17 February 2021

TfNSW Reference: SYD19/01486/03
Client Reference: SSD 10394

EXHIBITION OF EIS FOR ST JOHN OF GOD RICHMOND HOSPITAL - 177 GROSS VALE ROAD, NORTH RICHMOND

Figure 35. Proposed convex mirror location
Source: TTPP

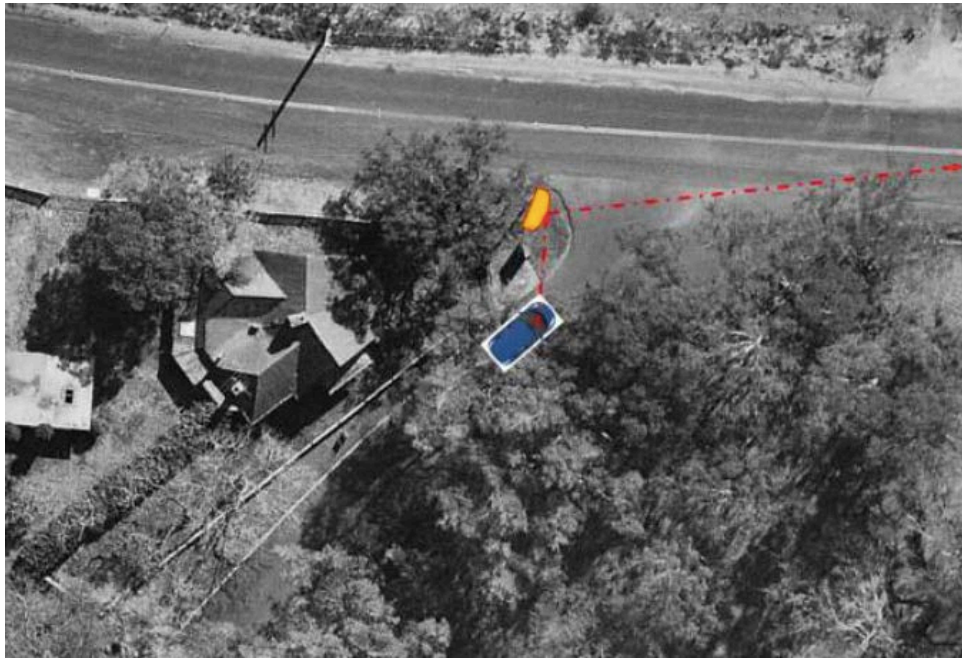
1. It is requested that prior to the issue of first Occupation Certificate, the applicant be conditioned to submit the final Green Travel Plan (GTP) to TfNSW at development.sco@transport.nsw.gov.au for endorsement with consultation with TfNSW. The final GTP should include:
 - Details of shuttle service for staff and/or patients and visitor to/from Richmond station;
 - Analysis of residential postcode data for existing staff and a breakdown of shift patterns;
 - A Travel Access Guide (TAG) for staff, patients and visitors, detailing the sustainable arrangements available for all cohorts.
2. TfNSW does not support the proposed convex mirror at the Grose Vale Road at the existing Hospital access, due to the mirror showing misleading sight distance for oncoming vehicles. TfNSW notes that convex mirror is only appropriate for local roads with low traffic and speed environment.
